Our Case Number: ABP-314610-22

Re: BusConnects Ballymun/Finglas to City Centre Core Bus Corridor Scheme
Ballymun/Finglas to Dublin City Centre

BALLYMUN FINGLAS SCHEME no 314610

Drawing File Name: BCIDD-ROT-GEO\_GA-0304\_XX\_00-DR-CR-0016  
 Sheet Number: 16 of 37  
 Status: A  
 Rev: M01

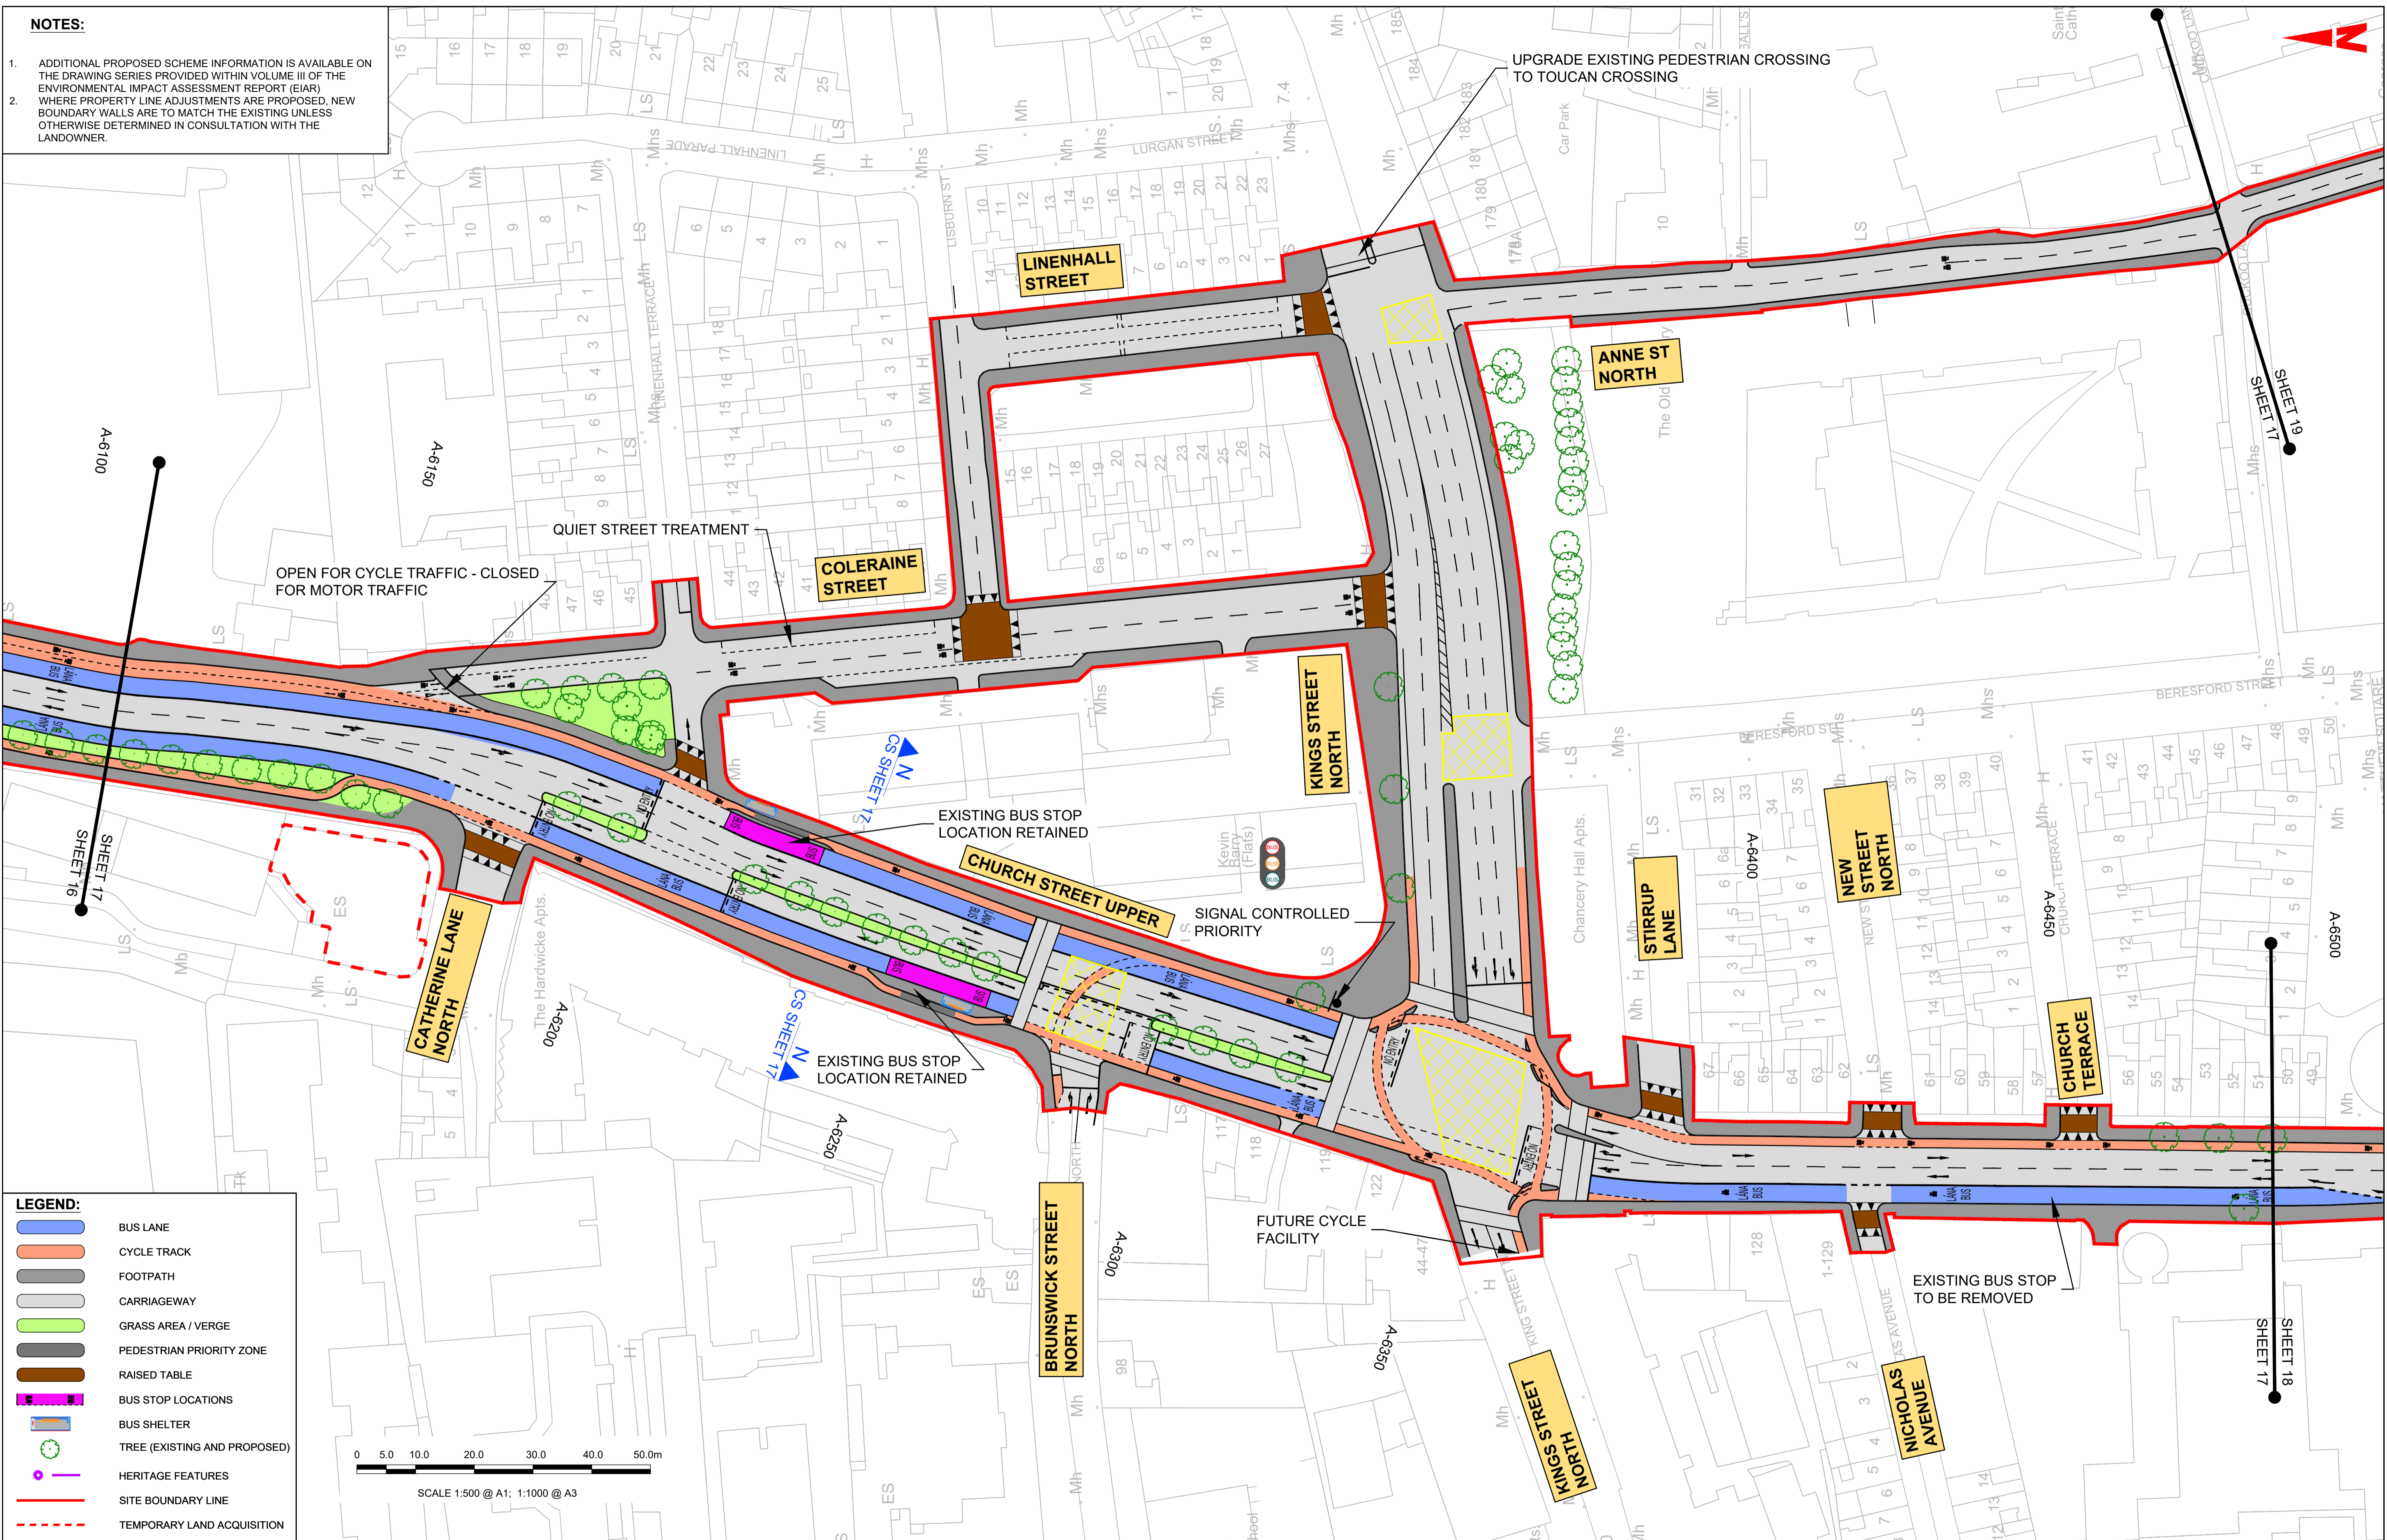
It is noted that under the BusConnects proposal the E buses will leave the corridor at Western Way. All that will be left on Church Street are a relatively unimportant 23 and 24 service with a proposed 3 services an hour each. These follow very circuitous routes through Finglas/Ballygall and are unlikely to be used by anyone in a hurry. There appears to be no justification for bus measures on Church Street as suggested by sheet 16, 17 and 18 of the drawings supplied.

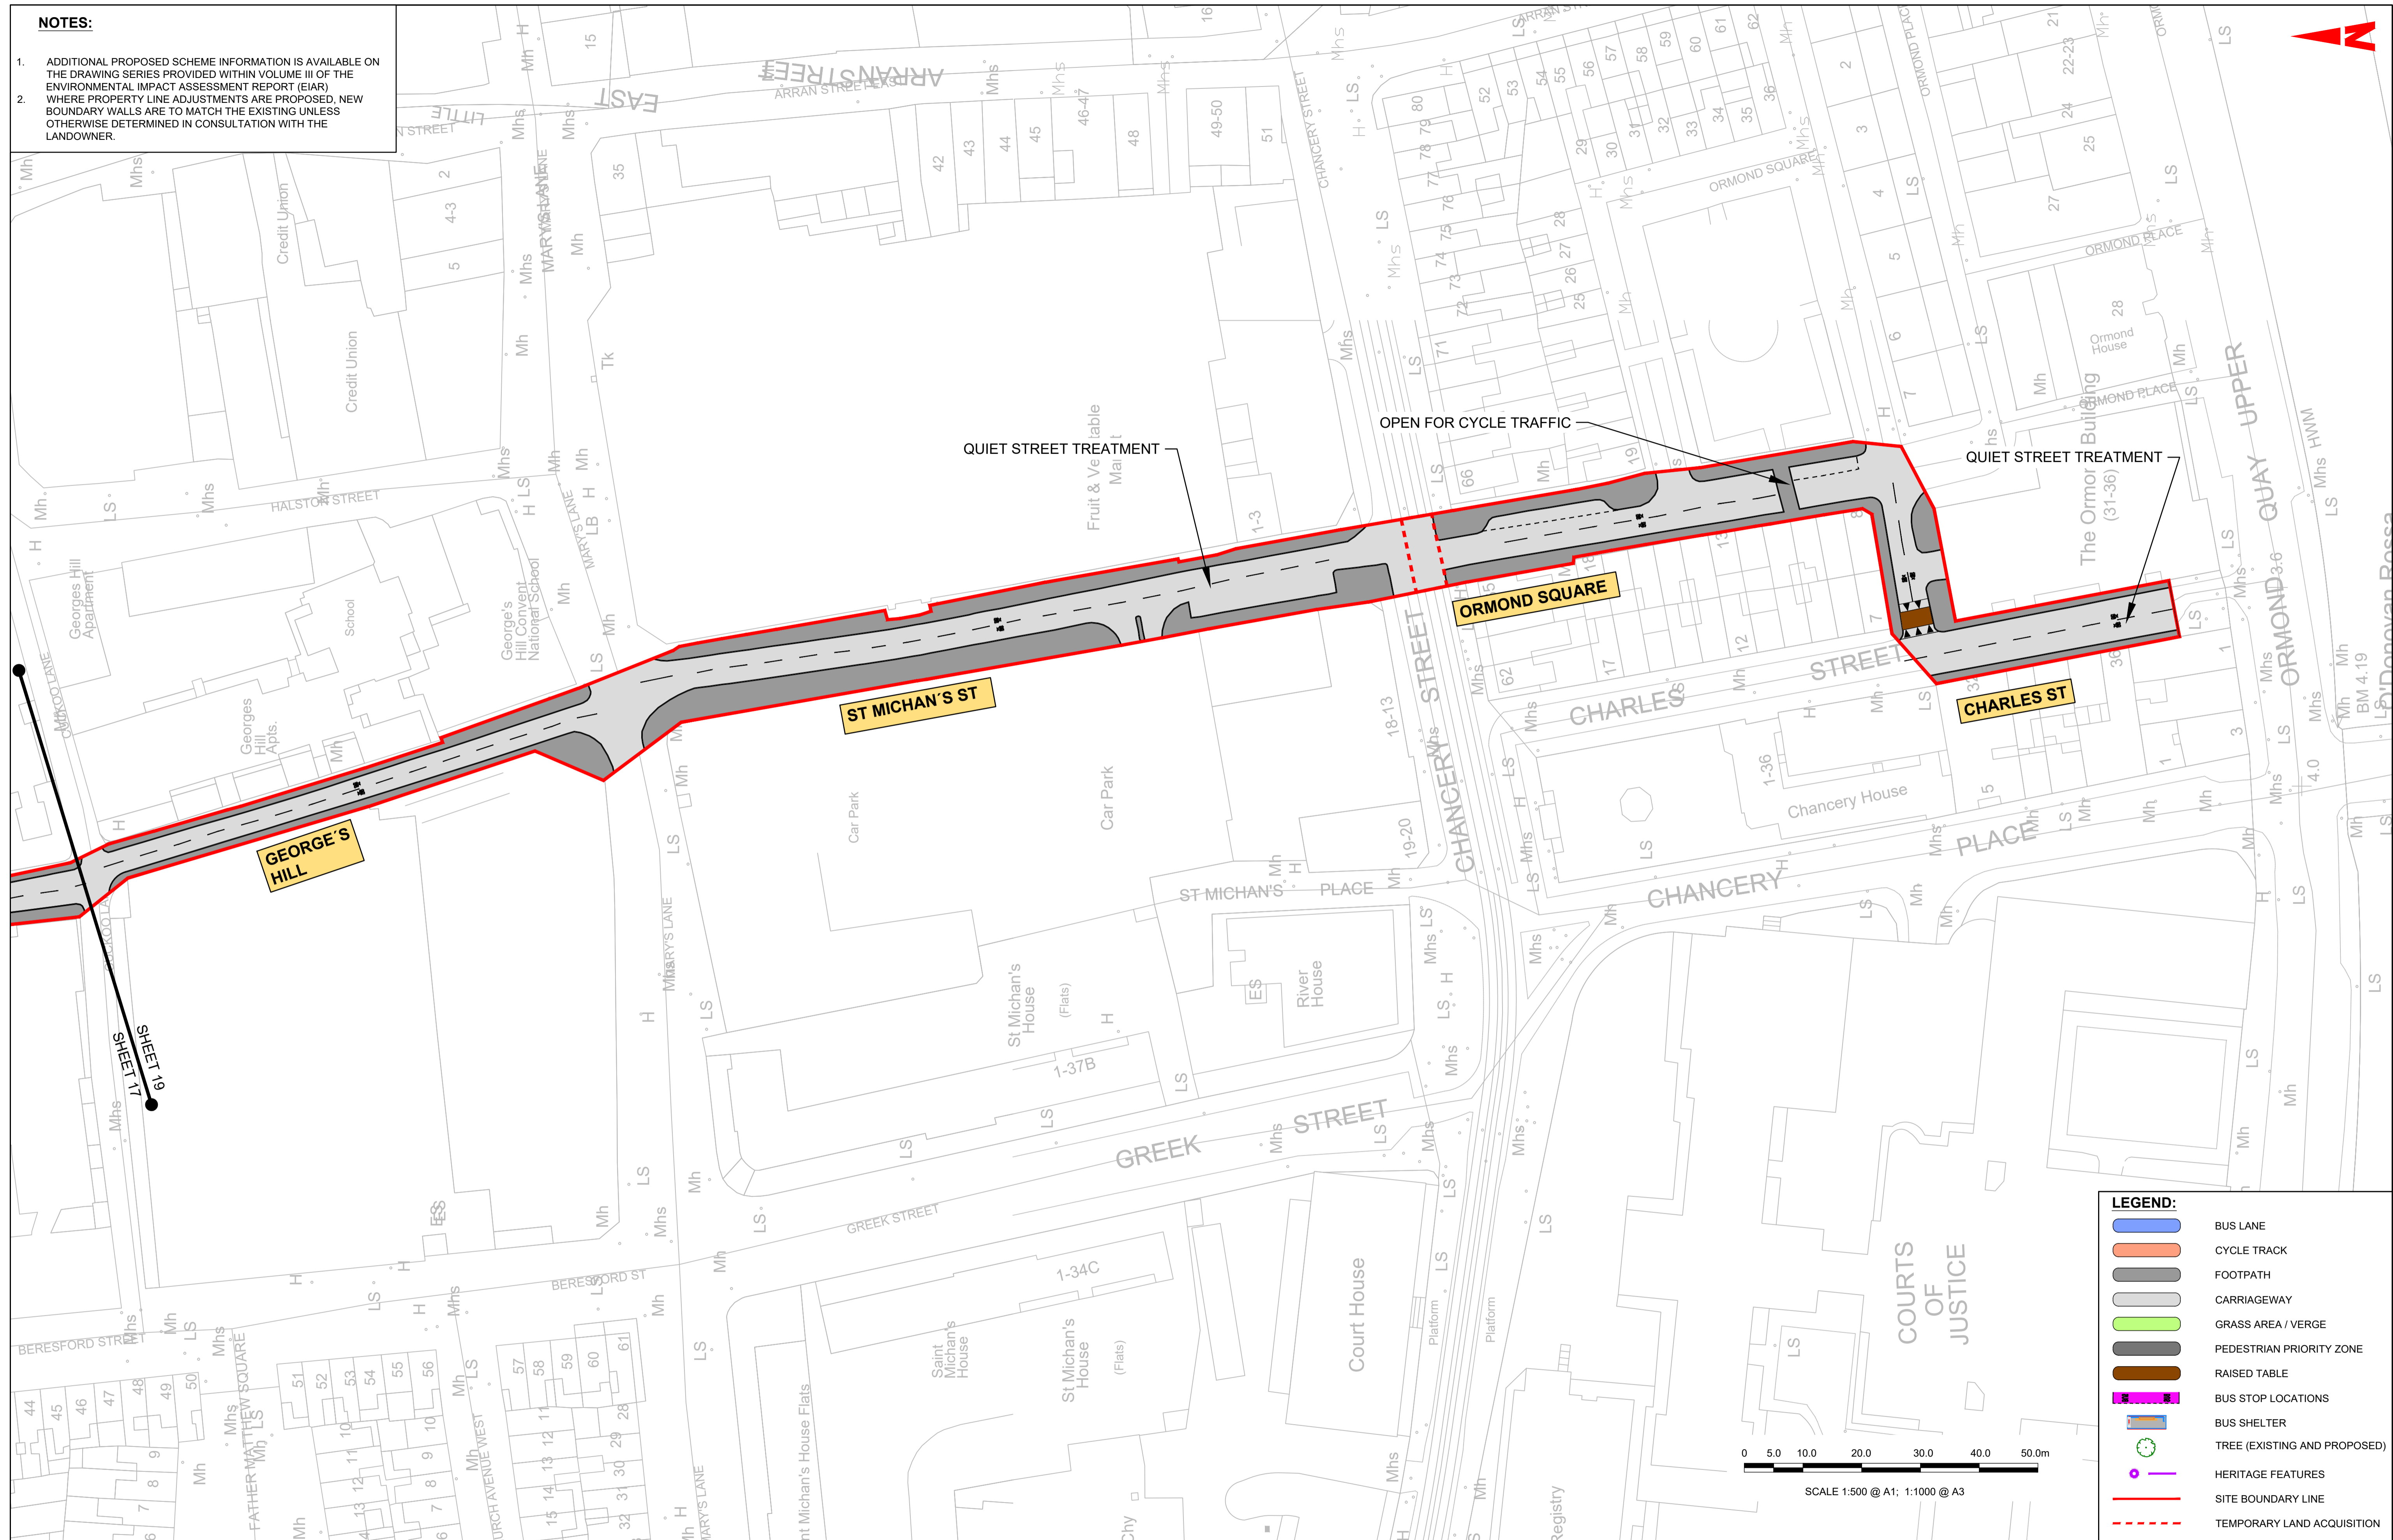
It would seem far preferable that you use the road space on Church Street to provide continuous cycle lanes to the North Quay rather than the intermittent cycle lane evident from drawing 18 on substantial sections of Church Street. This is particularly so given that cycle lanes are omitted on large stretches of Phibsborough Road.
